**Jeanie Bourke - 140003 = Revised CAN-01 for Shucks Maine Lobster**

**From:** "Sturtevant, Dana" <DSturtevant@sheridancorp.com>  
**To:** Building Inspections <buildinginspections@portlandmaine.gov>, "JeanieBou...  
**Date:** 7/17/2014 8:38 AM  
**Subject:** 140003 = Revised CAN-01 for Shucks Maine Lobster  
**Attachments:** 2014-07-01 Demising Wall REV 5 DAMA 7-14-16 (1).pdf

Good morning. Here is our revised CAN-01 stamped plan dated 7-16-14 that makes the corrections noted in your e-mail dated 7-16-14.

DATE	REVISION	DRAWING STATUS	EST. NO.	ENGINEERING DESIGNS FOR	JOB NO.
7-16-14	STAIR DETAILS ADDED & DEMISING WALL DETAIL CHANGED		14-0003	SHUCKS MAINE LOBSTER	14-0003
7-14-14	REVISED LEASED SPACE AREA			Portland, Maine	
				Demising Walls & Doors	
				DESIGN BUILDER

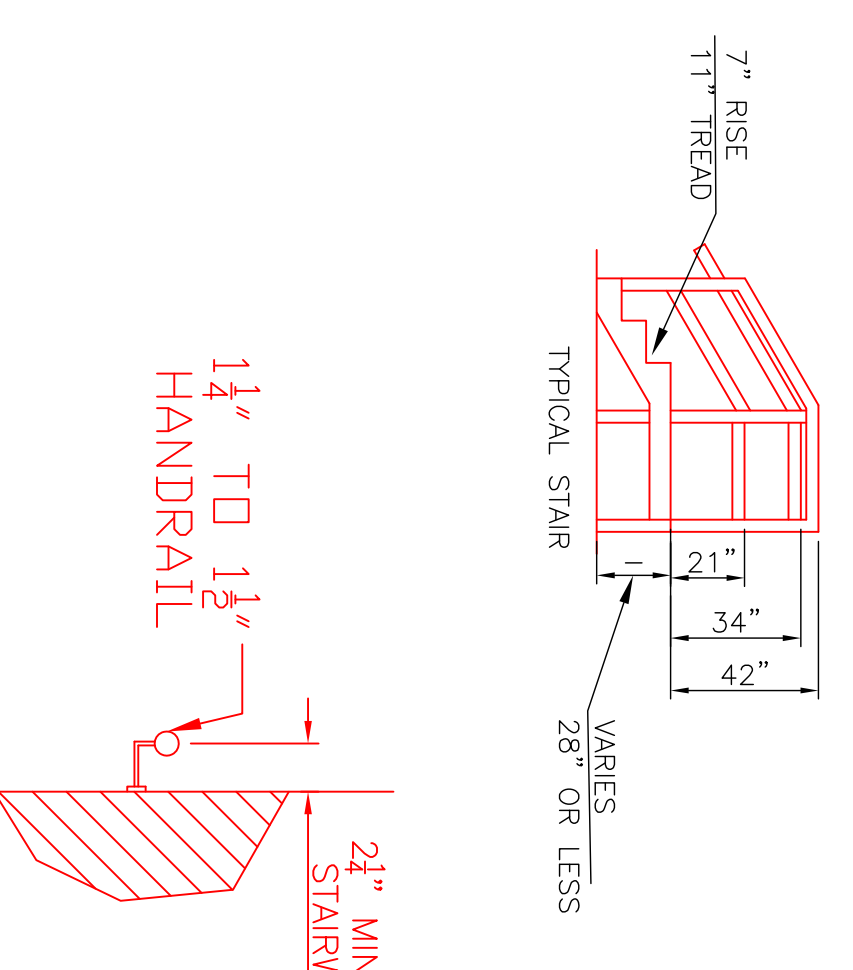
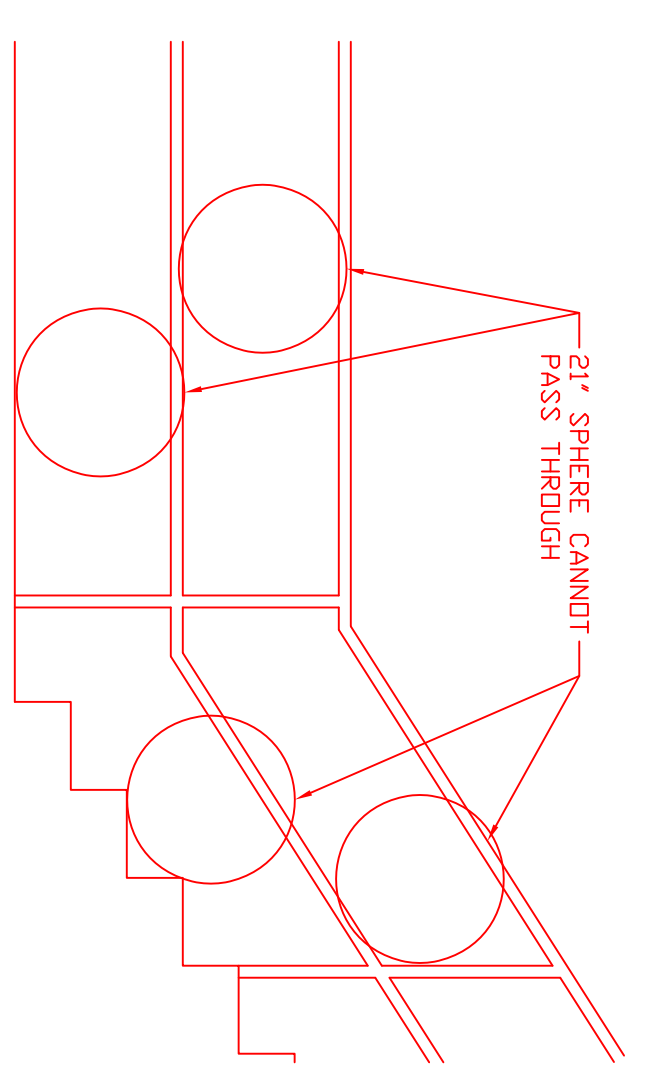
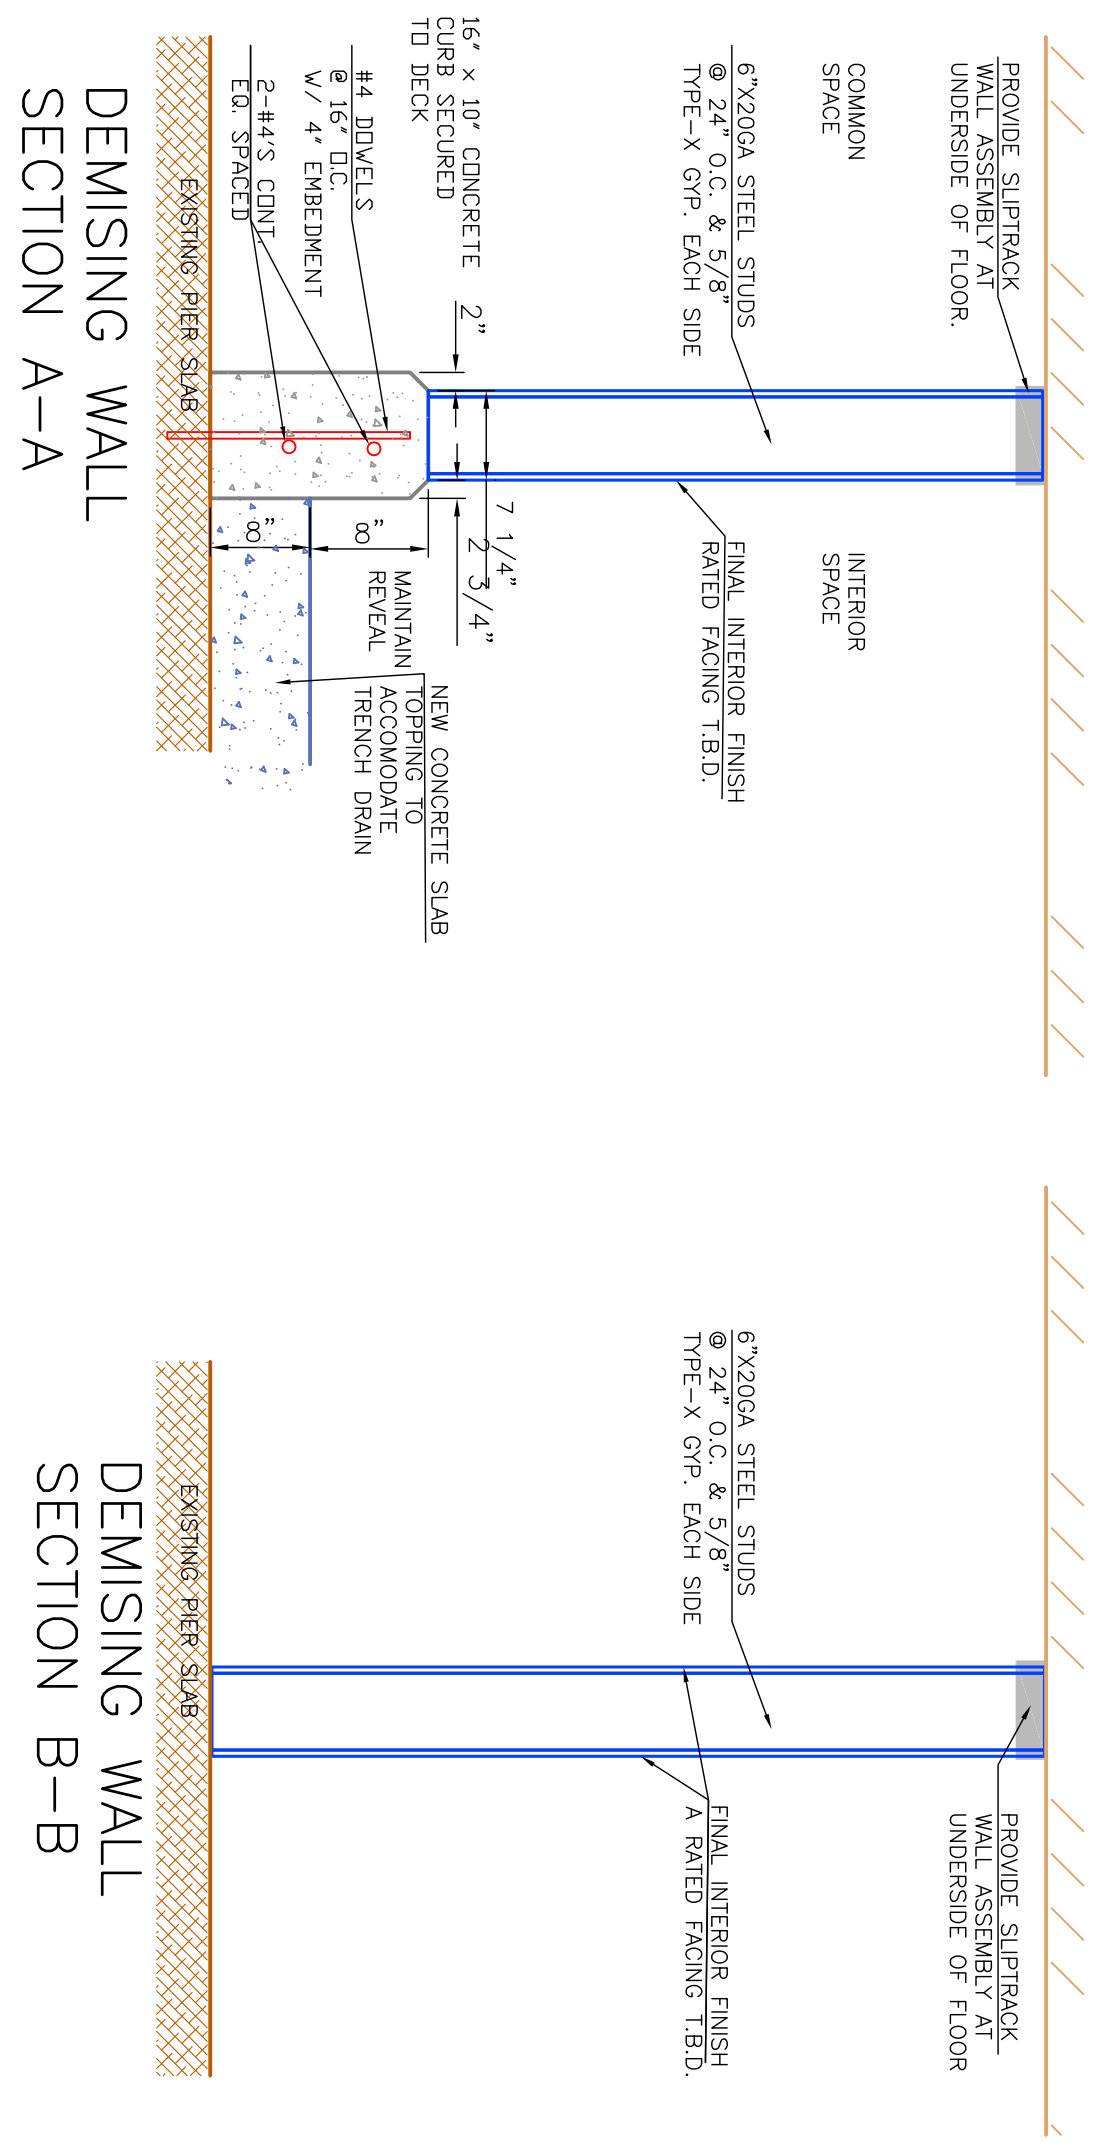
1. Stair revision showing the 11" tread; typical handrail vertical dimension; handrail rail offset and diameter; and guard rail dimensions.
2. Revised Sections A-A and B-B noting that the "Demising Wall" will be full height to the underside of the second floor above in the affected areas per IBC 707.3.8 which refers to 508.4 to 508.4.4.1

I had assumed the existing ceiling was the underside of the floor above and protected with a rated gypsum floor ceiling assembly. We will make this correction to abide by the IBC code noted here at the time of construction. The reference of either ceiling or roof was generic as at the time we were considering a demising wall at the single story building being a wood decked roof as well.
